30 August 2021

RE: RESPONSE TO SUBMISSIONS FOR SSD-10224, NEW PRIMARY SCHOOL AT EDMONDSON PARK

1 NORTH - EAST ELEVATION (BUCHAN AVENUE)
2000 1 : 250

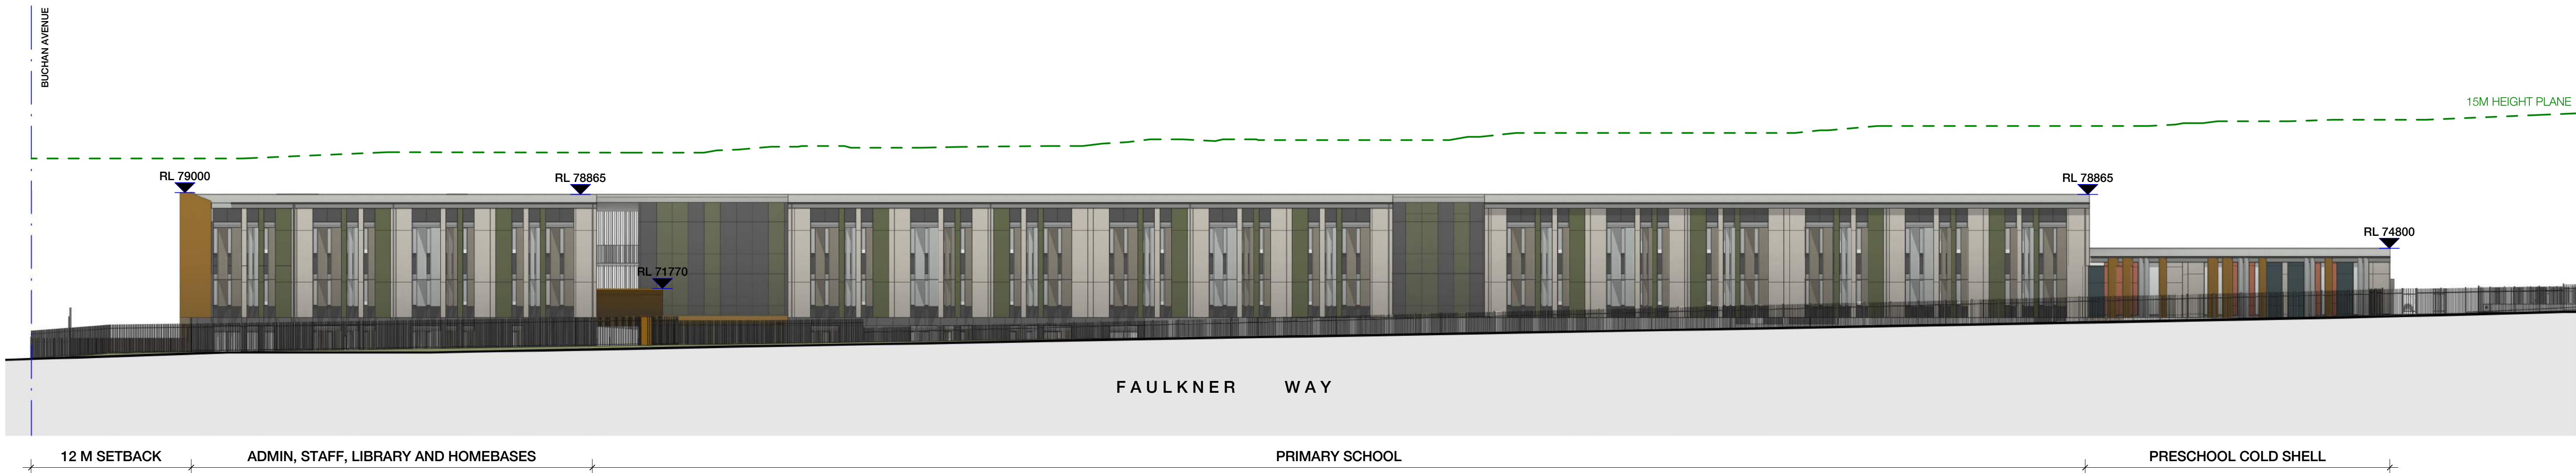
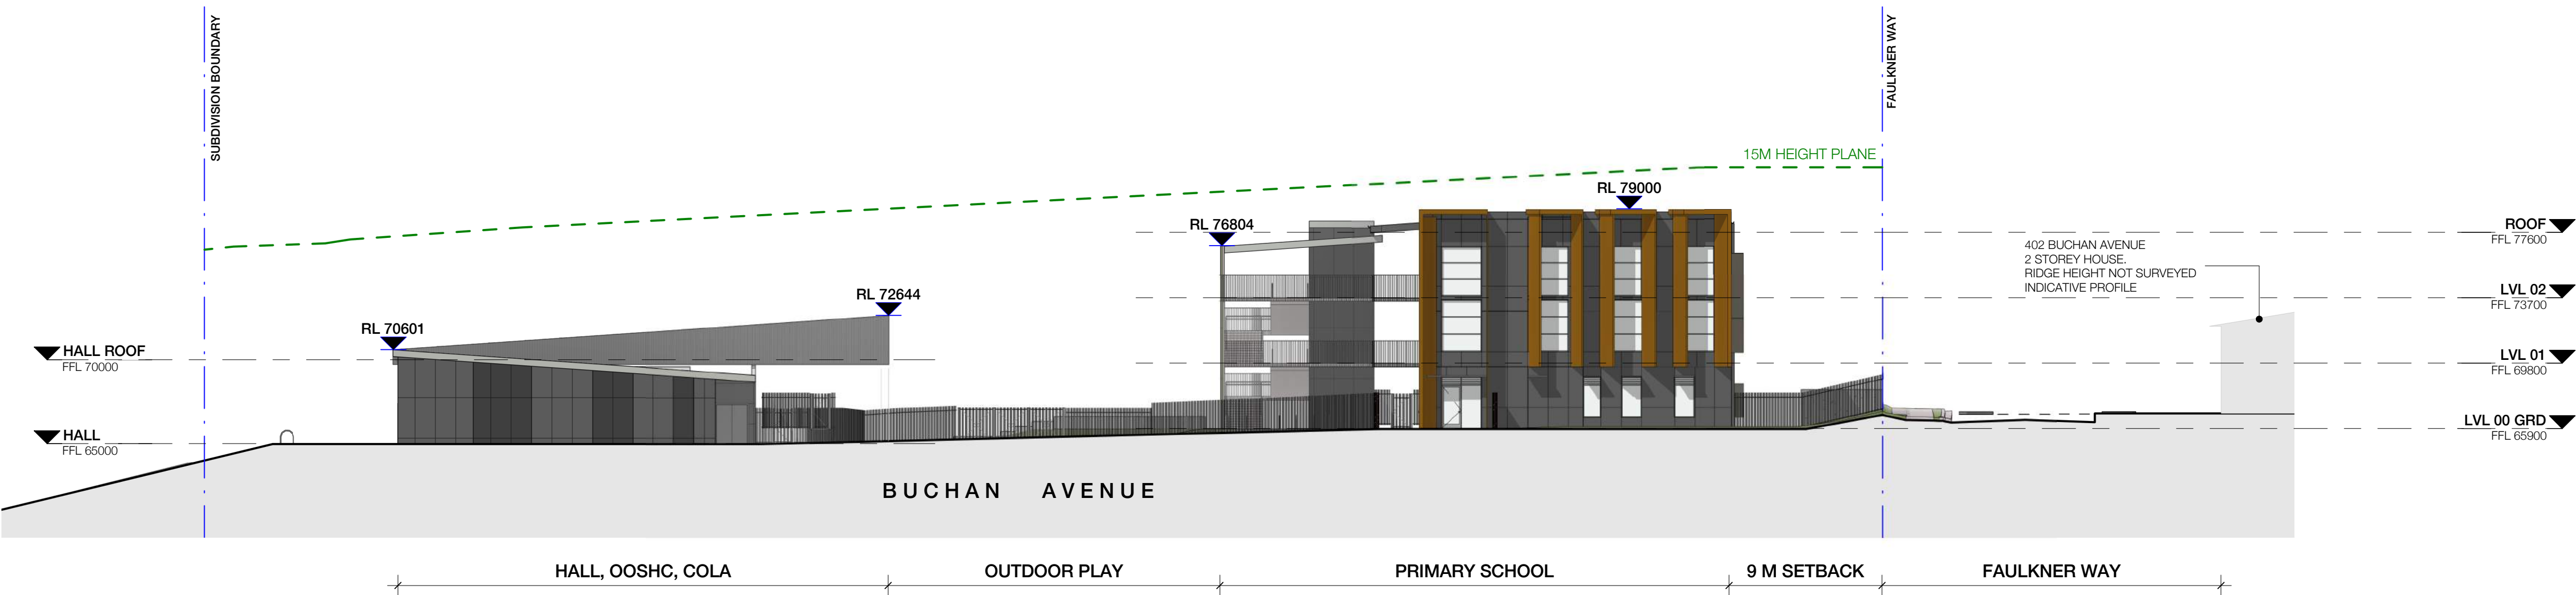
Agency	Summary of Matters Raised	Proponent's Response
Department of Planning, Industry and Environment	<p>Site Referencing</p> <ul style="list-style-type: none"> The EIS notes that boundary realignment works are underway to form the final site boundaries of the school. Consequently, the Department requests updated Lot and DP information be provided, including any updates required to relevant documentation. Provide sufficient evidence to confirm the removal of the electricity easement, given works are proposed in this locality. 	<p>As the DoE now owns Lot 2, the boundary realignment will be coordinated internally by the DoE property team and occur post/separate SSDA approval.</p> <p>Lot 1 and 2 Title Searches attached in Appendix 10 confirm the removal of the electricity easement.</p>
	<p>Design Excellence</p> <ul style="list-style-type: none"> Consider and respond to the matters raised at the State Design Review Panel (SDRP) meeting held on 23 June 2021 and listed in the advice dated 30 July 2021. Further refinement of the secondary entrance on Faulkner Way is required to address the SDRP comments to make the entry more welcoming and identifiable. Additional consideration should be given to design opportunities that may break the uniformity of the Faulkner Street elevation, when viewed from Gallipoli Drive, which is contributing to the perceived bulk and scale of the school. 	<p>TKD and Oculus have prepared a response to the matters raised by the SDRP in cover letters and amended plans in Appendix 2 and 3 respectively.</p> <p>In summary, the Faulkner Way secondary/SSU entrance has been amended by:</p> <ul style="list-style-type: none"> Increasing the alcove in length and width, presenting a larger gathering space; and Provision of an awning over the support unit outdoor play area to provide weather protection and to improve legibility / wayfinding in the streetscape. <p>The awning is proposed to adopt the same materiality and colour as the solar shading devices on the Buchan Avenue elevation, see below figure.</p>

Agency	Summary of Matters Raised	Proponent's Response
		 <p data-bbox="1368 676 2042 730">Figure 1: Perspective of the amended Faulkner Way entrance (Source: TKD)</p> <p data-bbox="1368 746 2042 898">The proposed awning, compatible materiality and rationalisation of the sunshades are all modifications that cumulatively break up the uniformity of the elevation and minimise the bulk and scale of Block A as viewed from Gallipoli Drive and Faulkner Way.</p>
	<p data-bbox="385 919 607 943">Traffic and Parking</p> <ul data-bbox="385 951 1346 1038" style="list-style-type: none"> • Further justification for the shortfall of on-site car parking spaces is required and consideration should be given to increasing the amount of car parking spaces provided on-site. 	<p data-bbox="1368 919 2042 975">PTC has prepared a detailed response to the traffic and parking matters raised in Appendix 12.</p> <p data-bbox="1368 983 2042 1410">As part of traffic investigations for both upgrades to existing schools and for the development of new schools, SINSW requires an holistic review of measures to assist in decreasing private vehicular use and increasing active transport modes. A School Transport Plan dated 26 May 2021 was submitted with the EIS. This plan will be implemented and monitored to promote active and sustainable transport uses by the school community. The site is located within walking distance of a train station and bus services. The proposal provides 42 on-site parking spaces accommodating 64% of the Liverpool DCP requirement. The new school includes 6 bicycle spaces and an end of trip facility for staff. Considering the above, we consider there to be sufficient provision of on-site</p>

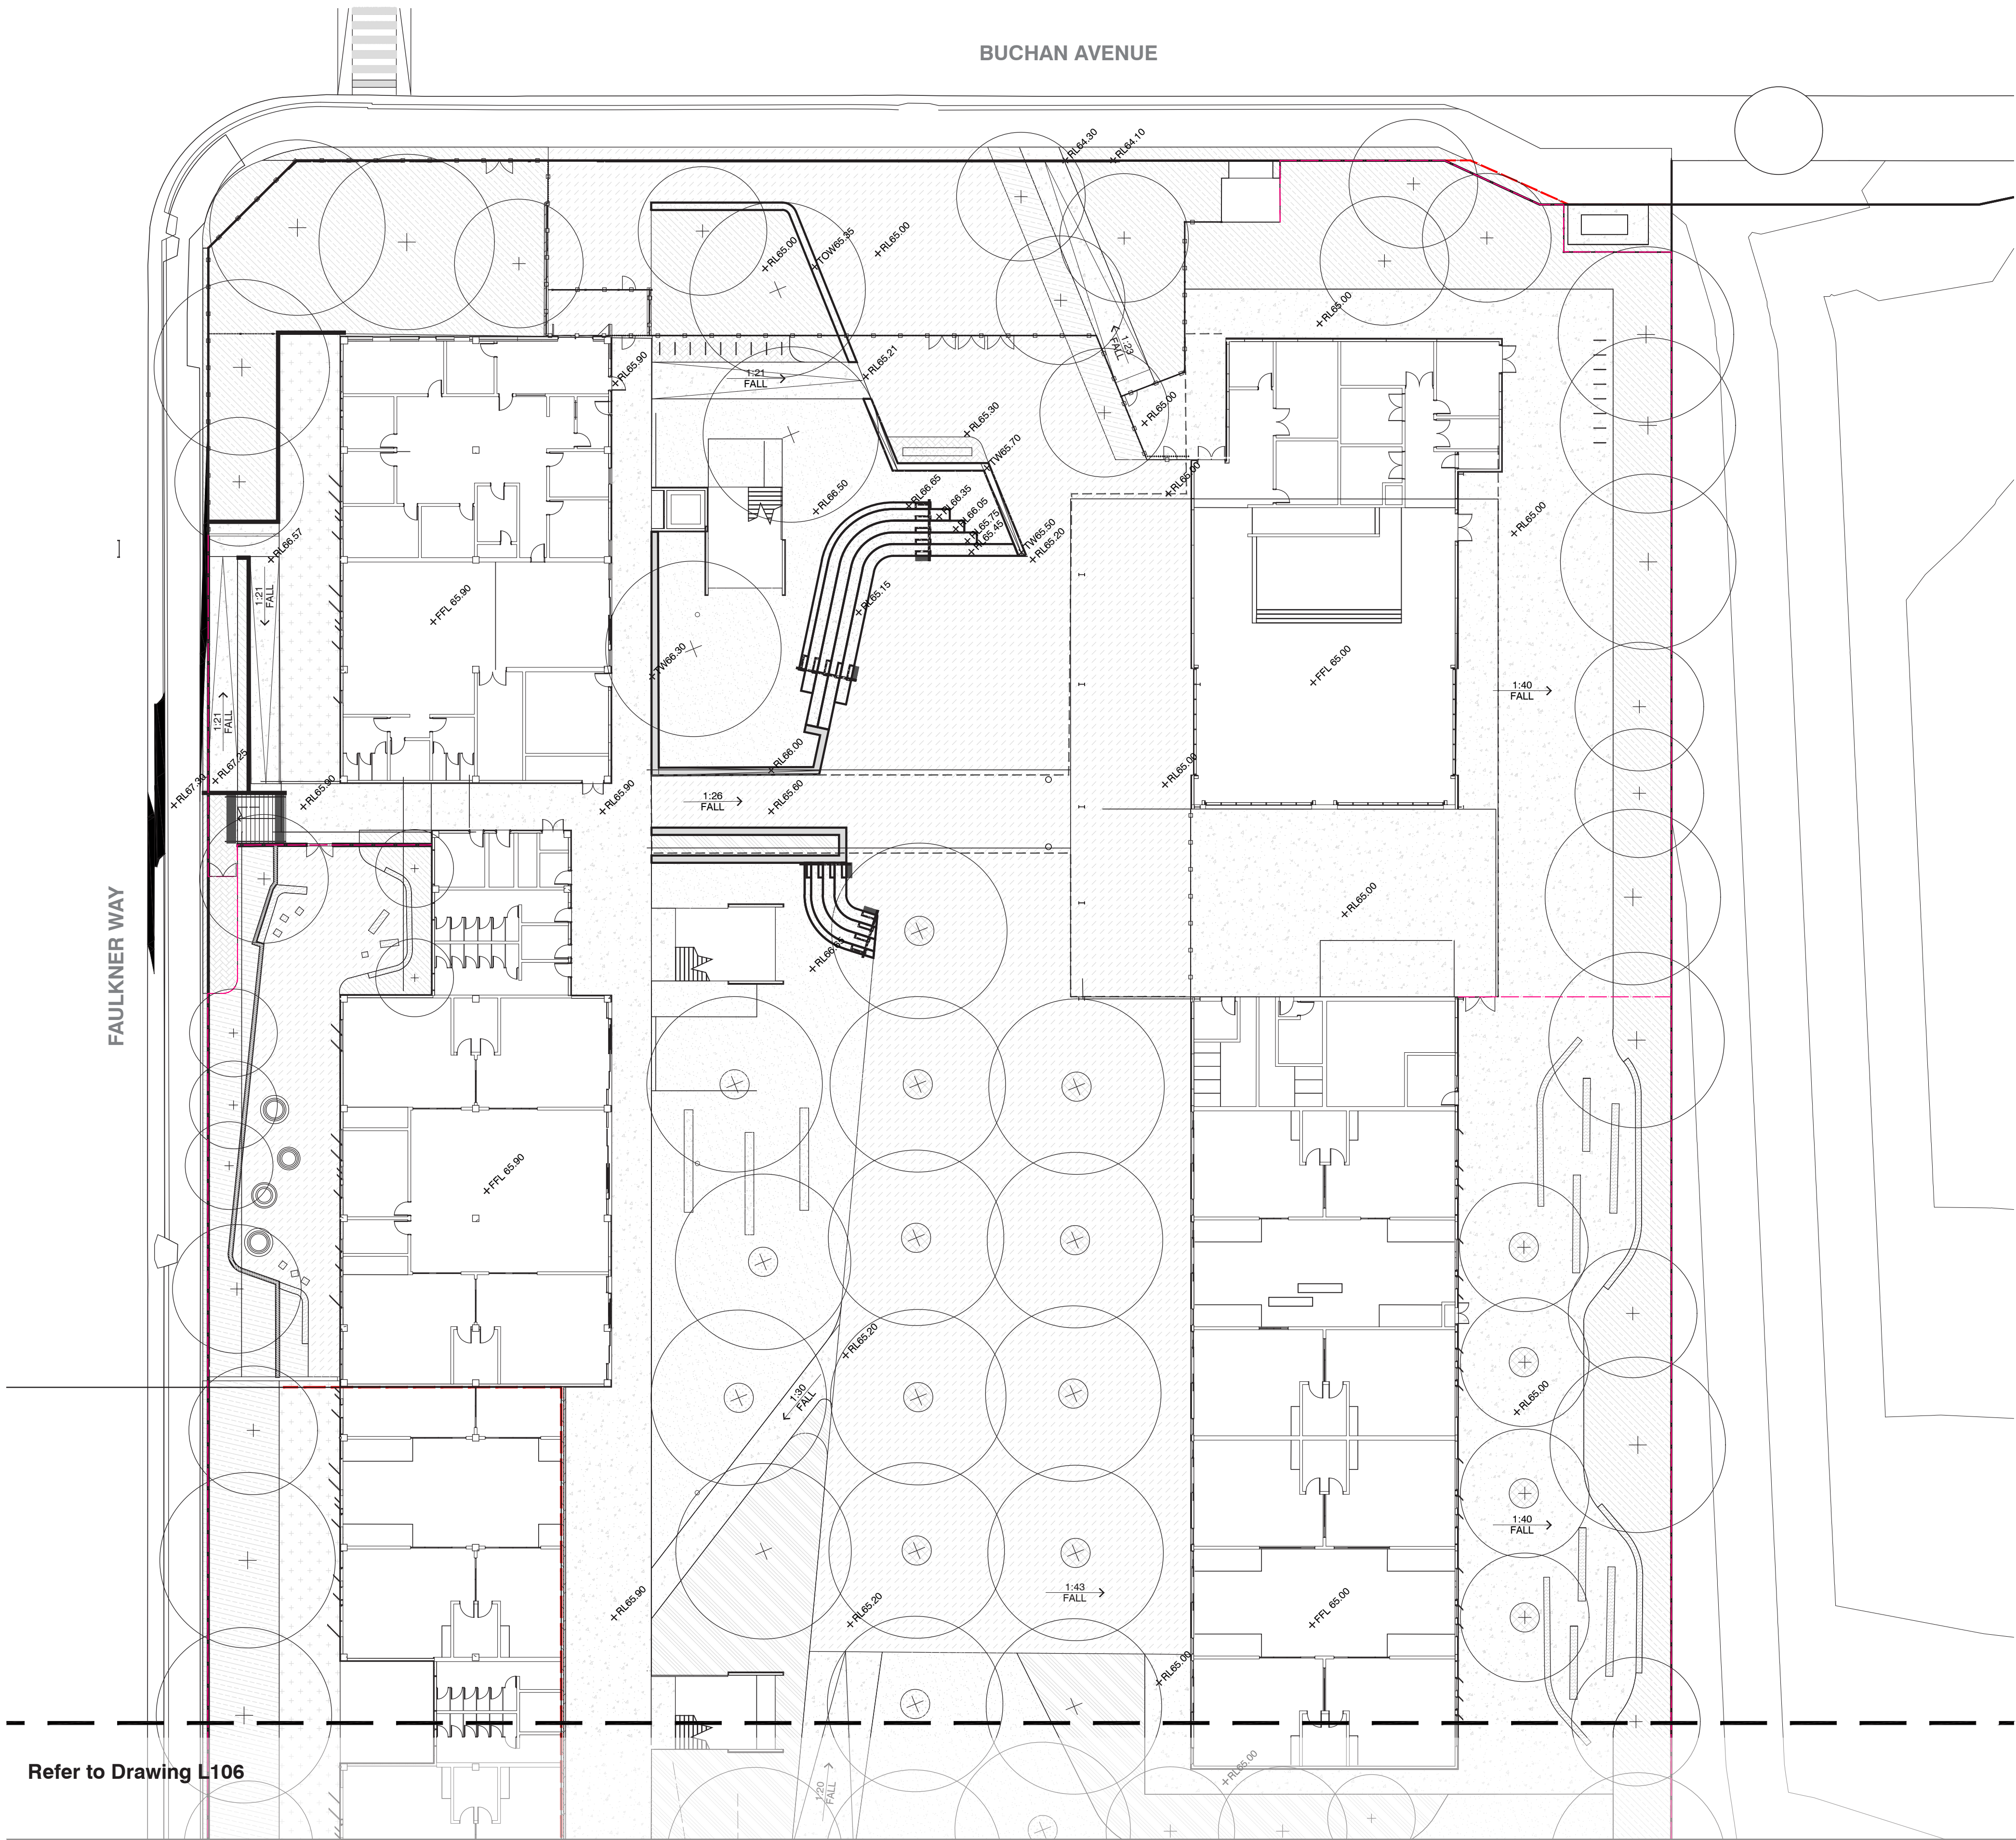
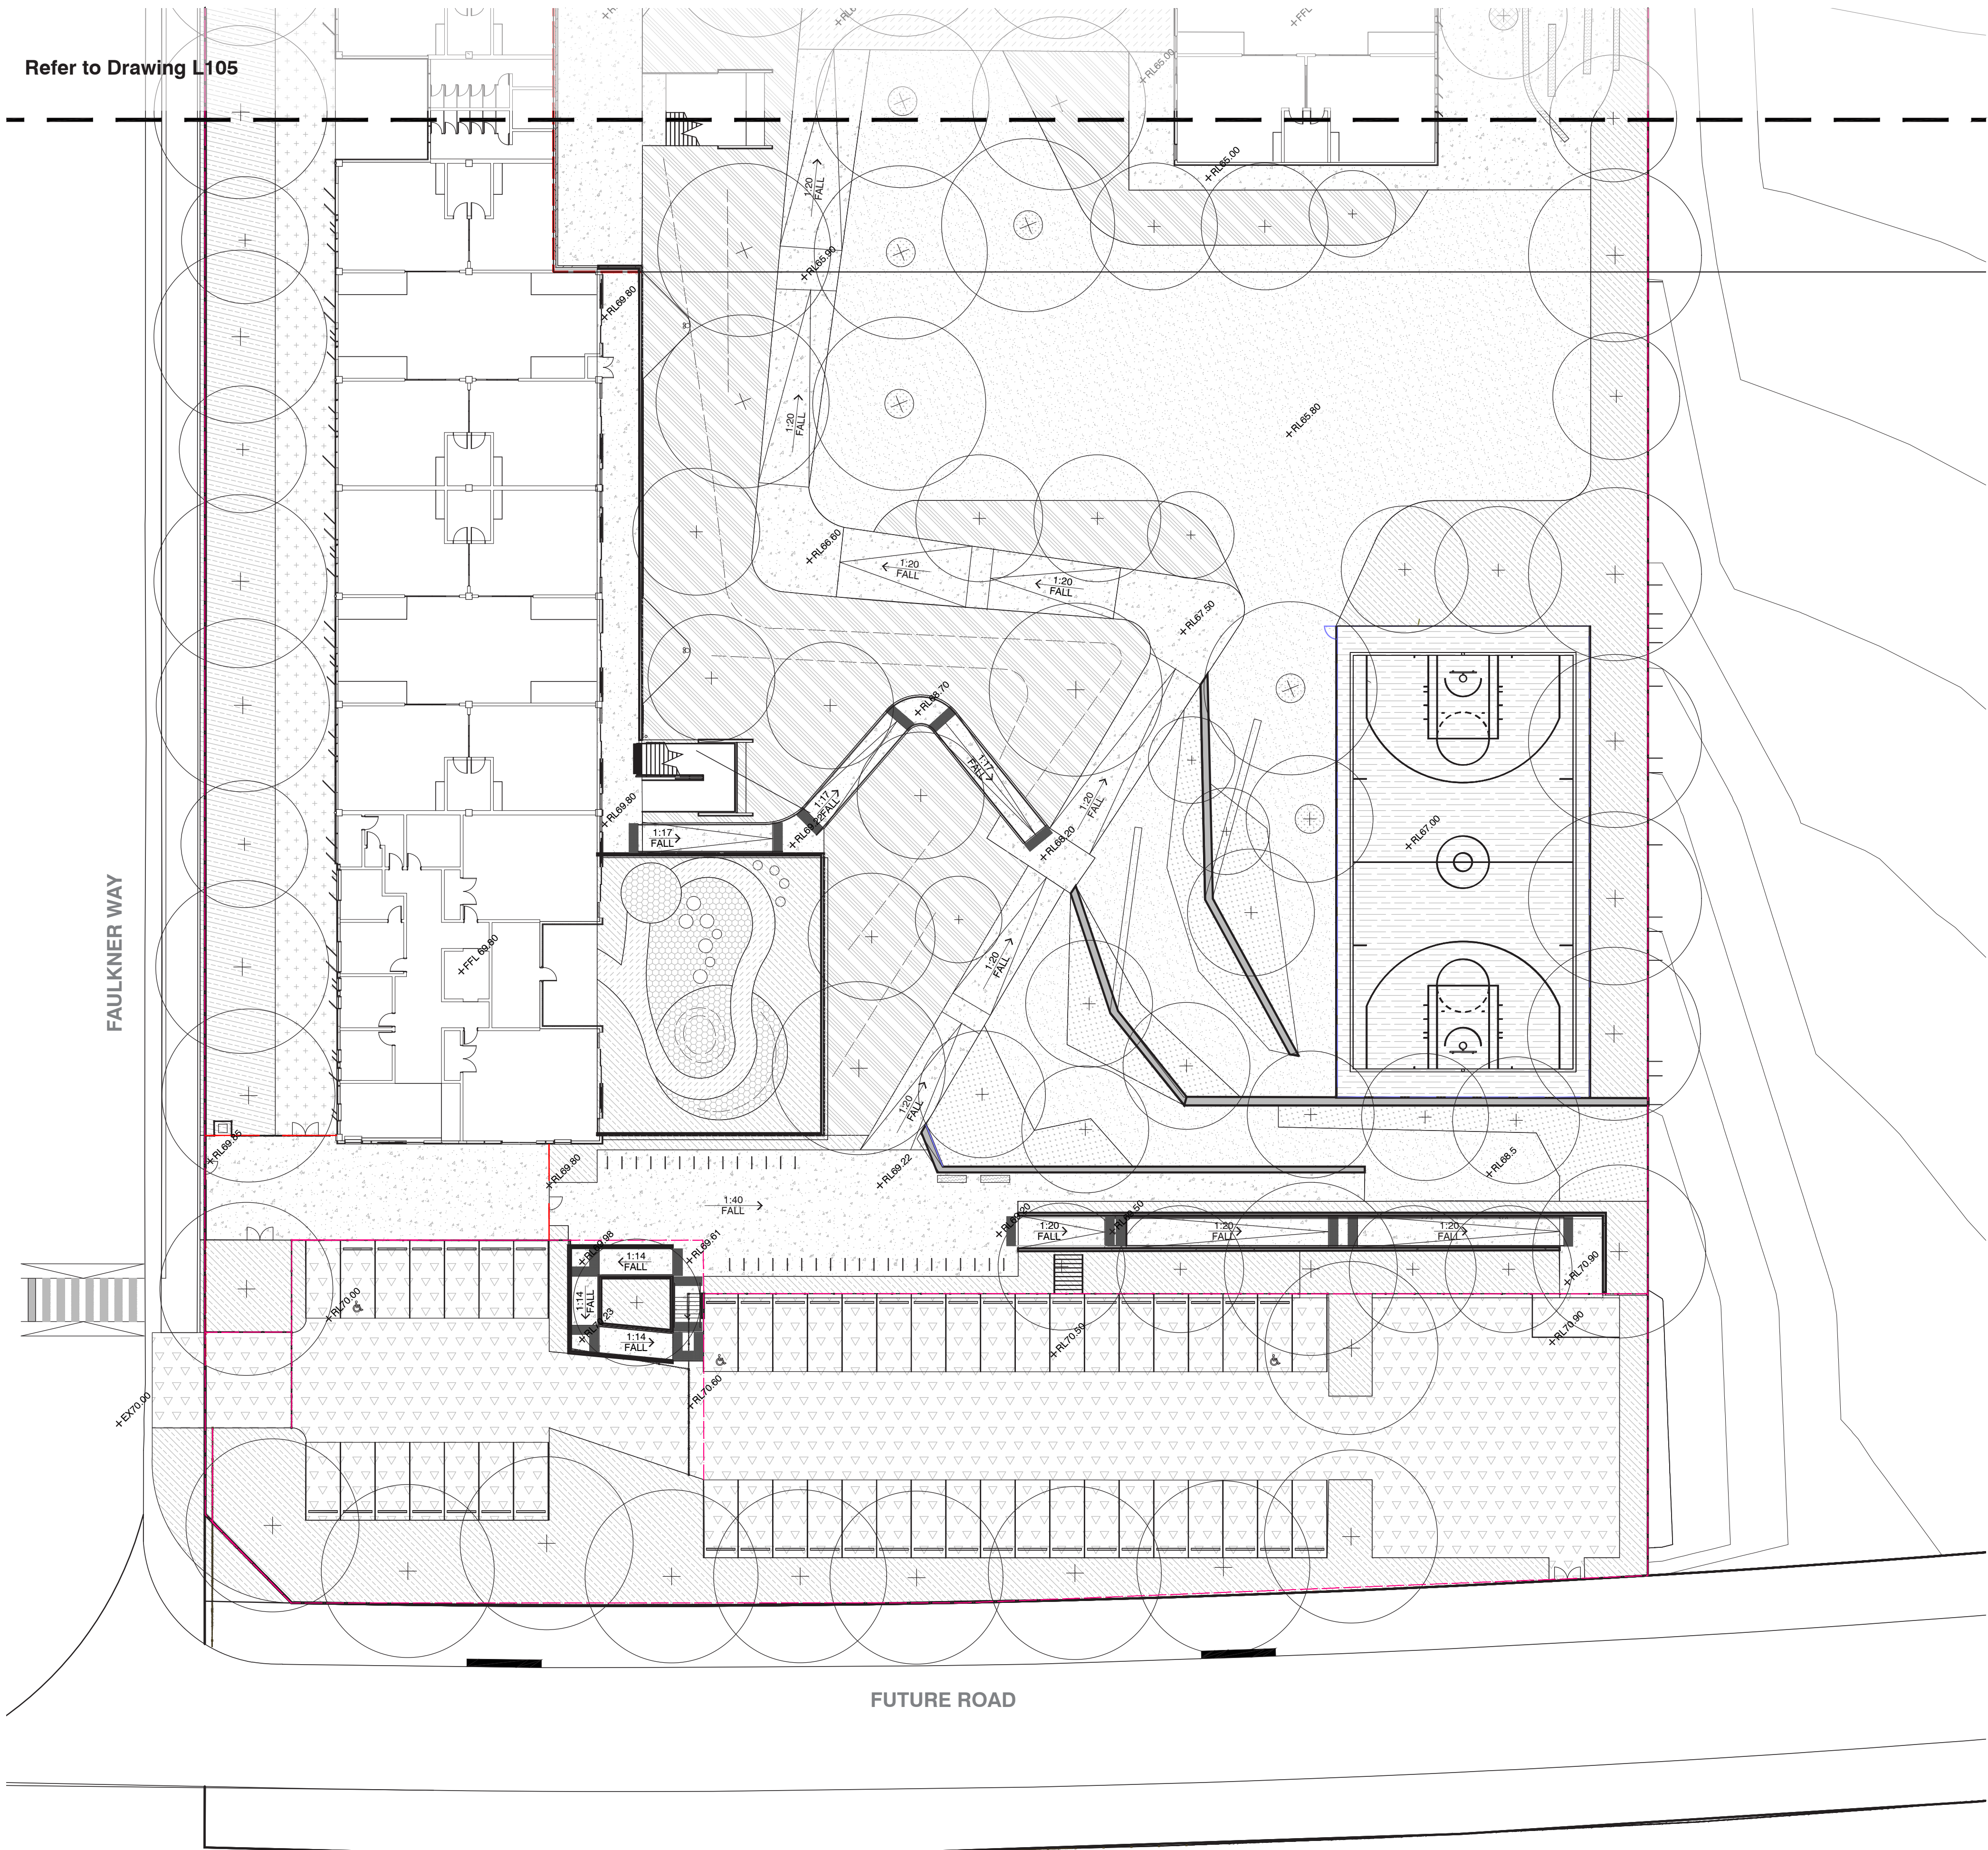
<p>Landscape masterplan indicates street trees in Buchan Ave inconsistent with other drawings.</p>	<p>Oculus has rectified the inconsistencies. Refer to Appendix 3.</p>
